Our reference: ECM 9513209  
Contact: Gavin Cherry  
Telephone: (02) 4732 8125

14 April 2021

**Response to Notice of Exhibition – SSD-8571481 – TAFE NSW Construction Centre of Excellence at 2 – 44 O’Connell Street Kingswood**

Swept Path Analysis

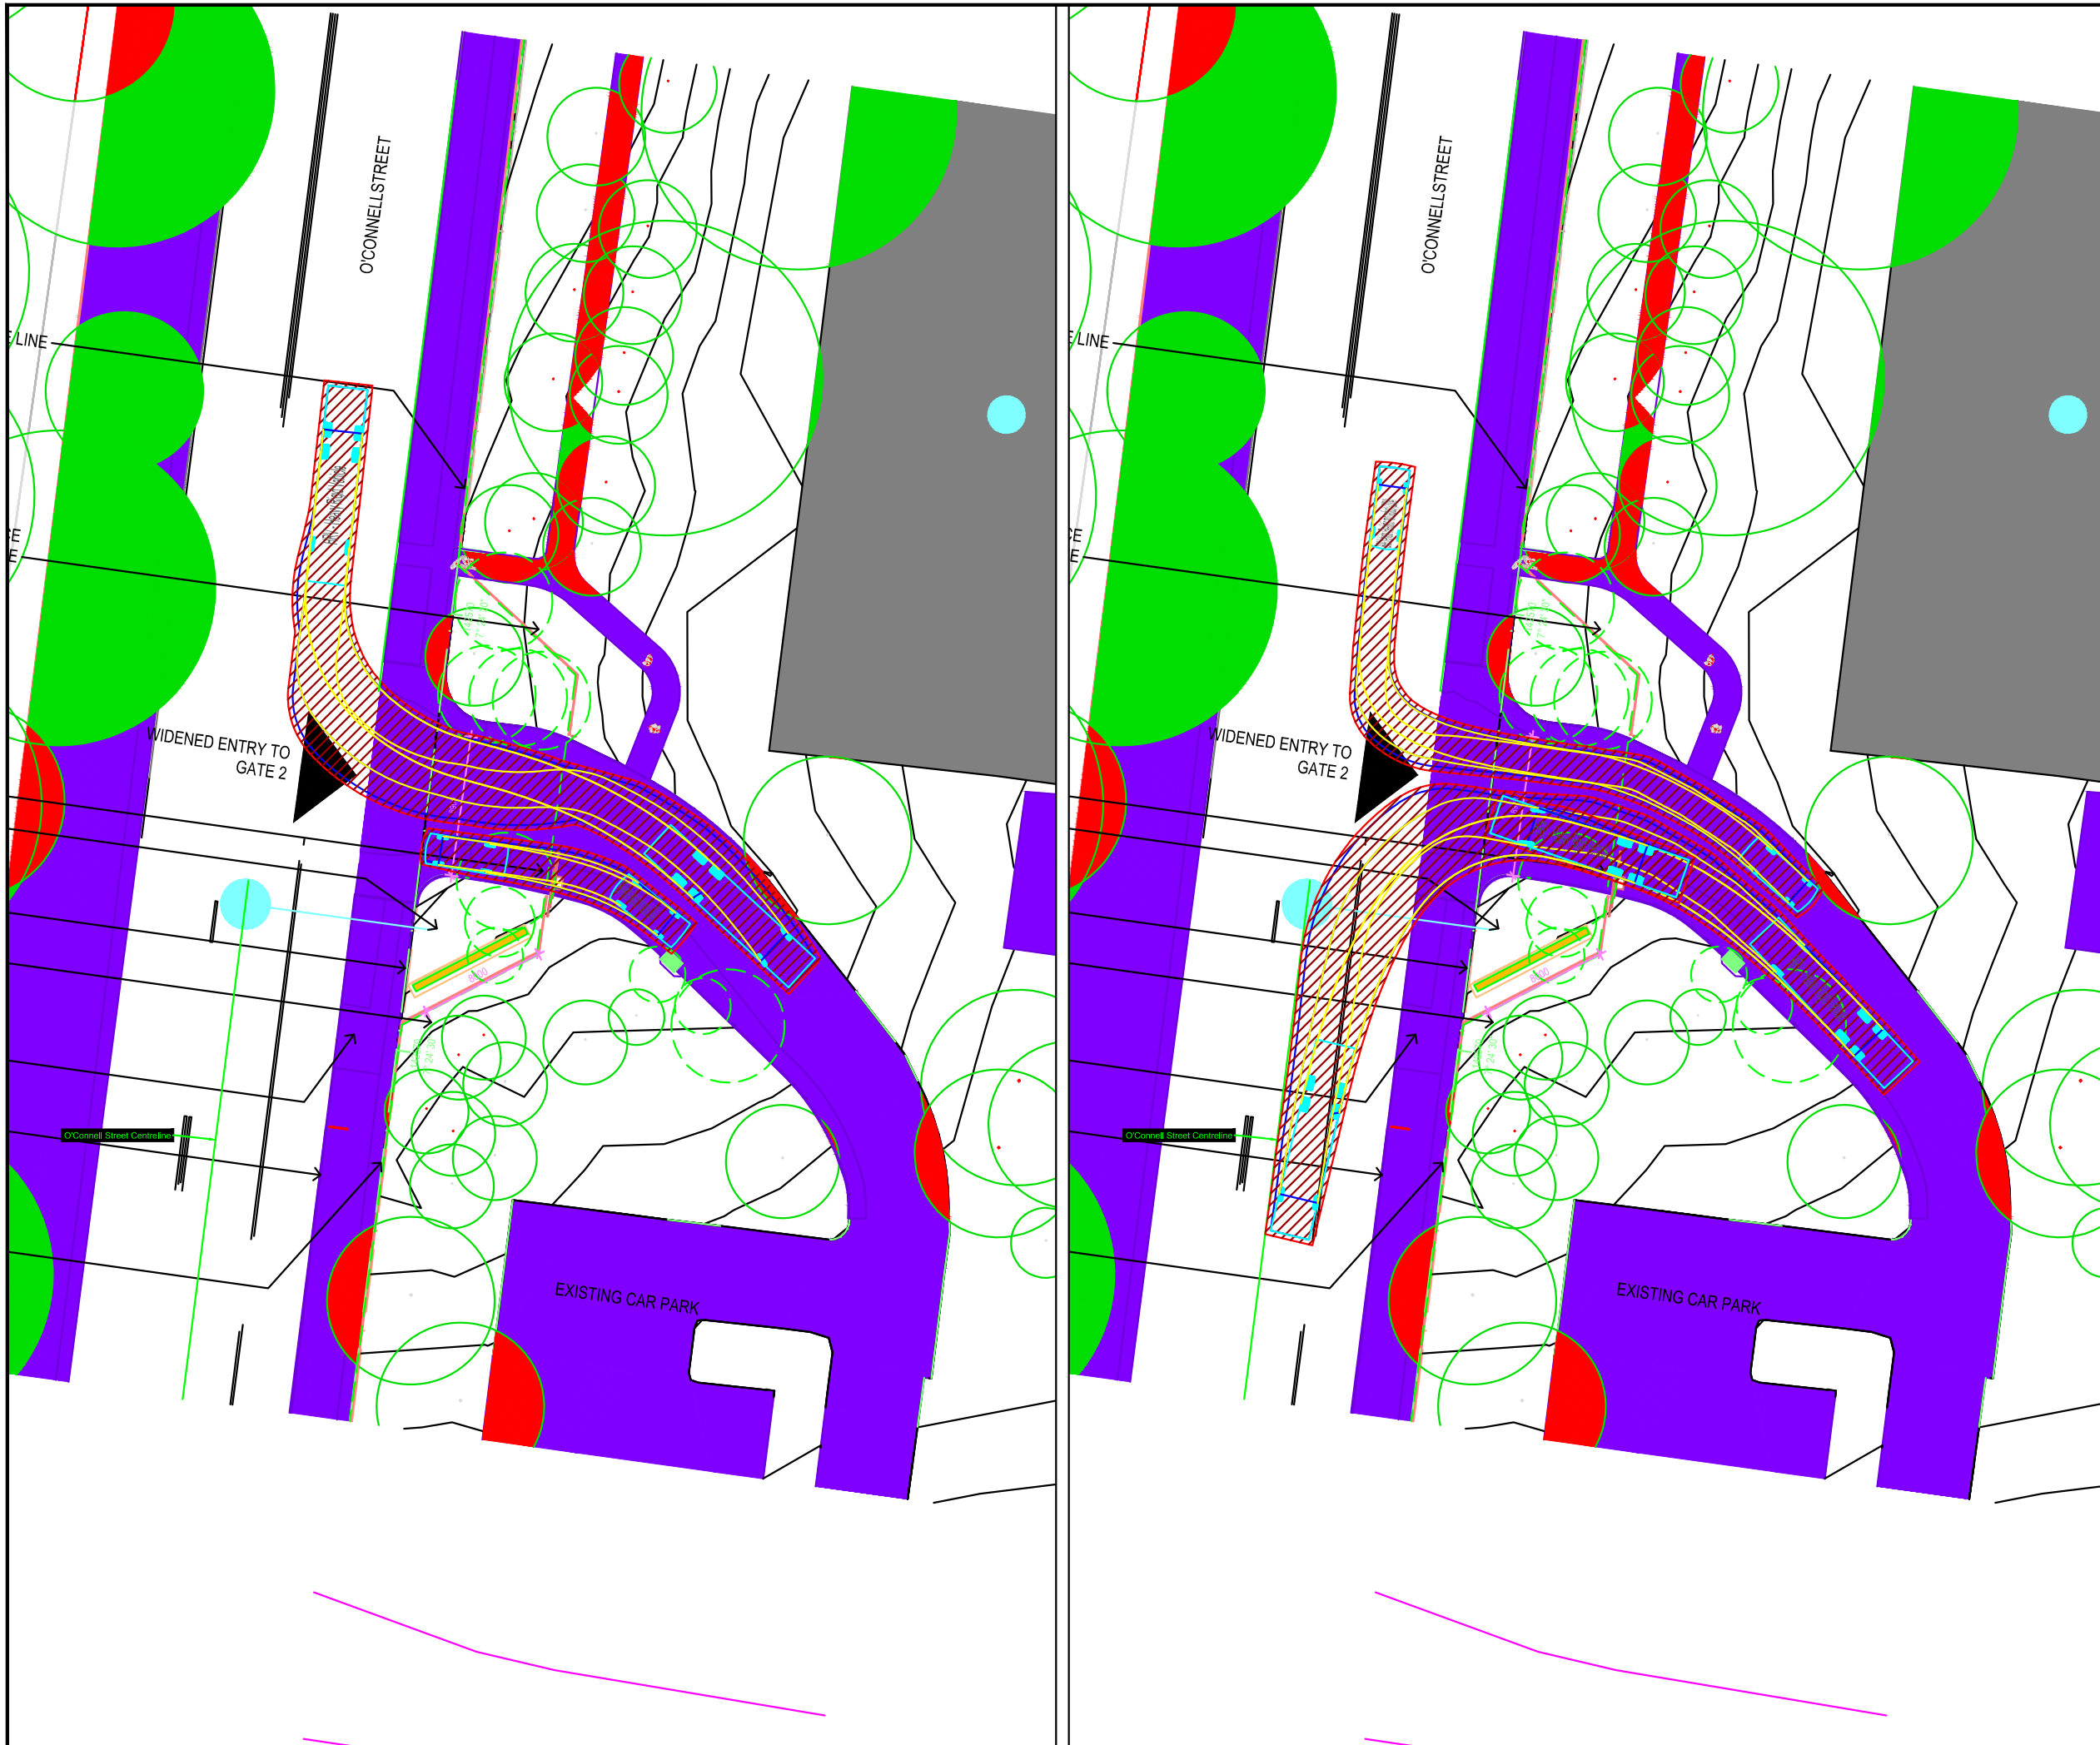
- The provided swept paths in the traffic report appear to show the service vehicle taking up the majority of the width of the circulation roadways and driveway. This is not appropriate, is unsafe and the driveway and circulation roadways should be widened to accommodate passing of the service vehicle and a passenger vehicle.
